**Application Reference: 2025/0366****Site Address:** 94 Ballfield Lane, Kexborough, Barnsley, S75 5JE**Introduction:** This application seeks full planning permission for the proposed erection of 2 storey rear extension and single storey rear/side extension.**Relevant Site Characteristics**

REAR ELEVATION (W)
SCALE 1:100

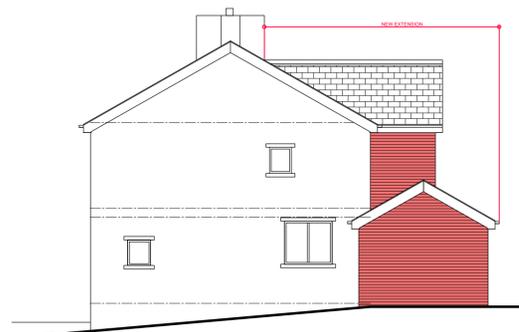
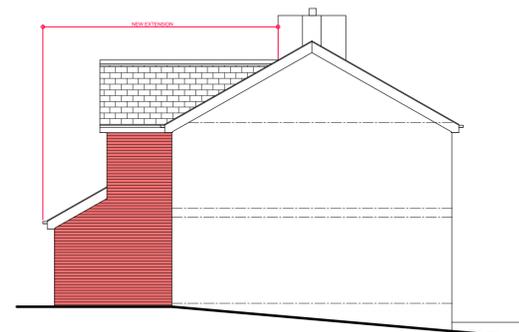
The extension has been considerably designed and overall would have a minimal effect on the amenity of the attached neighbouring dwelling. However, it must be mentioned that whilst the first-floor aspect of the extension has been designed to not breach the 45-degree rule in relation to the view from the first-floor neighbouring window, unfortunately the ground floor extension does breach the same 45-degree rule in relation to the ground floor patio doors of the neighbouring dwelling. Mitigation for this breach firstly arises from there being no objection from the neighbouring dwelling. The second aspect of mitigation arises from the extent of the breach, in similarity to the 3m rear projection limit allowable through permitted development, the ground floor extension at 3.33m would, like a 3m permitted development extension breach the 45-degree rule. Having thoroughly checked the measurements, requesting the applicant to reduce their extension by 0.33m, or to request that a triangular shaped corner of approximately 1.21sqm be removed from the extension would not result in any significant change on the amenity of the existing neighbours, who have not raised an objection, or upon future neighbours. With this being the only factor of the extension which could be considered not in accordance with local policy guidance; the impact of the proposal on neighbouring amenity would be considered as limited and would not amount to sufficient detriment to warrant refusal of the application.

As the dwelling is a corner plot, and with an approximate 12m distance from the rear elevation of the proposed extension to the rear garden boundary, and a minimum of 30m between the extension's first floor windows and any directly overlooked neighbouring dwelling, in accordance with local policy requirements, there would be little, or no harm caused to the neighbouring amenity of any dwellings.

GROUND FLOOR PLAN SCALE 1:50

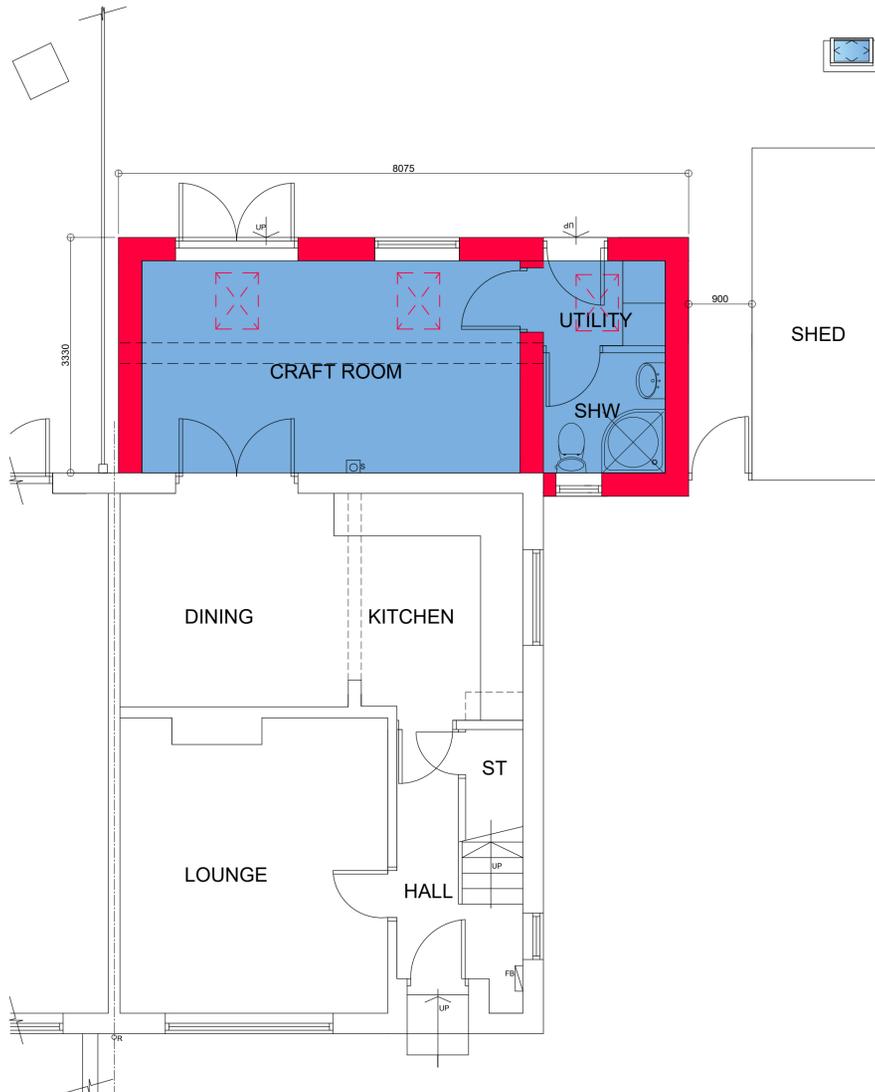
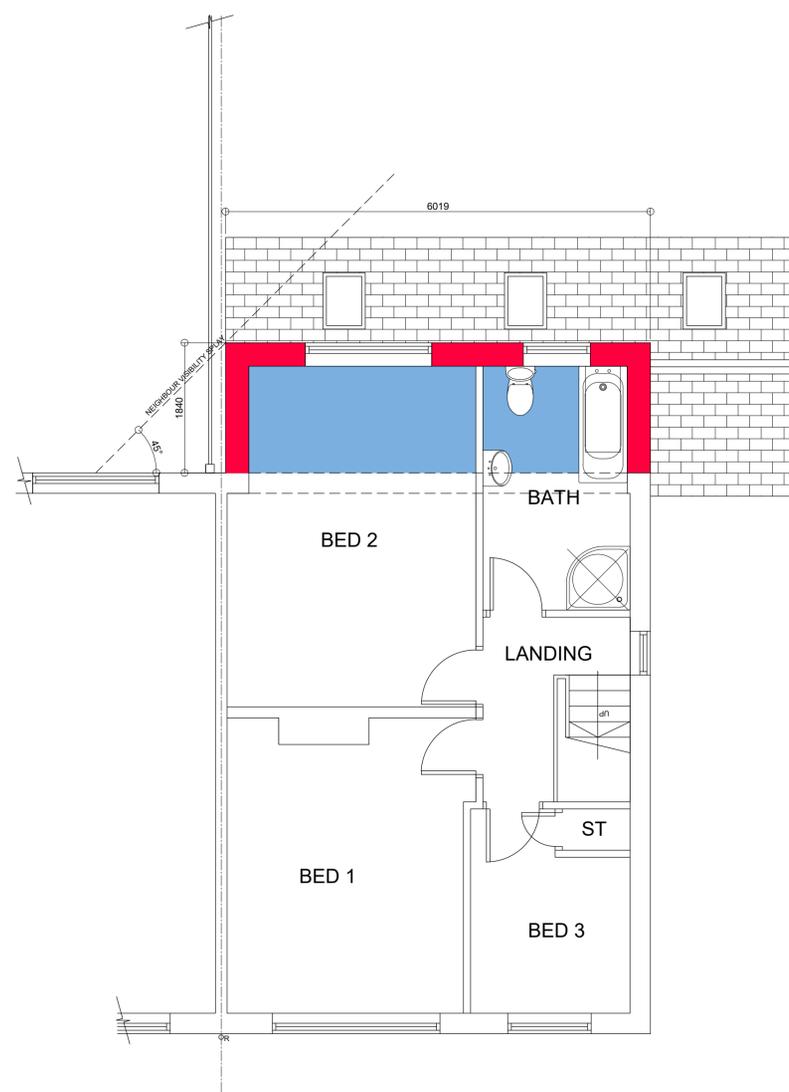
The proposal is predominantly for a ground floor rear extension which would extend beyond the corner of the rear and side elevation by approximately 2.06m and extend along the side elevation by just 0.33m. The rear extension would have a ground floor rear projection of approximately 3.33m whilst the proposal also includes a first-floor extension above which features a rear projection of 1.84m, and a width just narrower than the original rear elevation at approximately 6.02m. The section rear extension which 'wraps' around the side elevation would have a total rear projection of approximately 3.66m and feature a dual pitched, tiled roof with an approximate eaves and ridge heights of 2.2m and 3.59m respectively. The ground floor aspect of the extension would incorporate or replace the existing red brick outbuilding. The first-floor aspect of the rear extension would feature a gable style roof extension, with approximate eaves and ridge heights of 4.95m and 6.98m respectively. The ridge height of the extended roof would sit approximately 0.27m below the ridge height of the main roof. The ground floor aspect of the rear extension would feature a mono pitched tiled roof with an eaves height of approximately 2.2m, matching the side extension but with a slightly lower ridge height at approximately 3.37m.

The scale of the proposal is relatively proportionate to the size of the original dwelling and both the scale and design of the dwelling almost entirely comply with local policy. On corner plots the width of a side elevation is limited to either two thirds of the width of the original dwelling or 50% of the available space between the side elevation of the dwelling and the boundary. With a modest side projection of approximately 2.06m, the extension comfortably meets this criterion. With an approximate eaves height of 2.2m, an approximate maximum height of 3.59m and with mono, and dual pitched roof, along with the approx. 3.33m rear projection, the ground floor aspect of the extension meets local policy requirements. Equally, with a complementary style roof, set approx. 0.27m lower than the ridge height of the original roof's ridge height, and with a setback from the ground floor extension, the first-floor aspect also meets local policy requirements. The only breach regarding local policy is the 45-degree angle rule, which would be discussed in the neighbour amenity section below. Overall, the scale and design of the proposal would be an acceptable match for the existing dwelling, having a limited effect on the character of the dwelling, and little or no negative impact on the character of the street scene.

SITE PLAN
SCALE 1:250

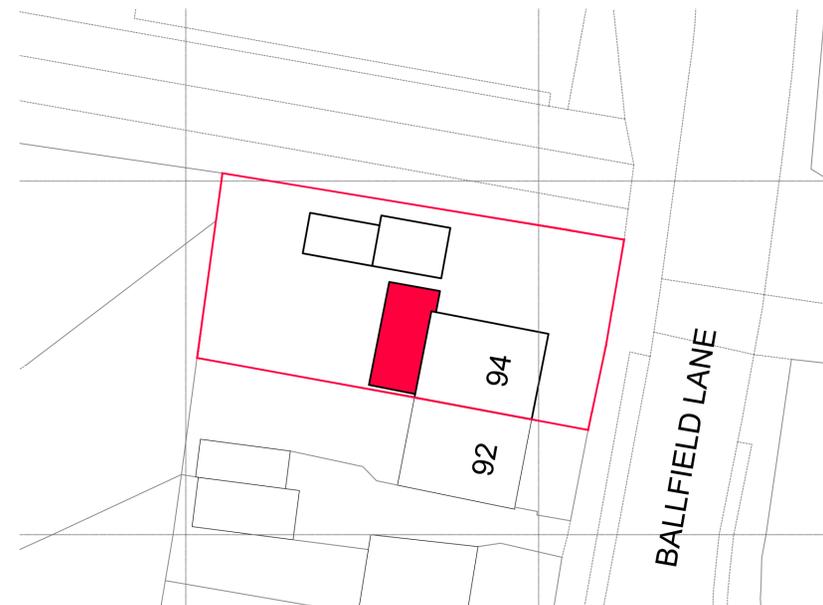
Although the side extension slightly protrudes onto the side elevation, and the rear aspect of the extension extends into the side garden, there remains an ample amount of parking provision for the size of the dwelling. Therefore, there would be no impact on parking provision or Highway Safety.
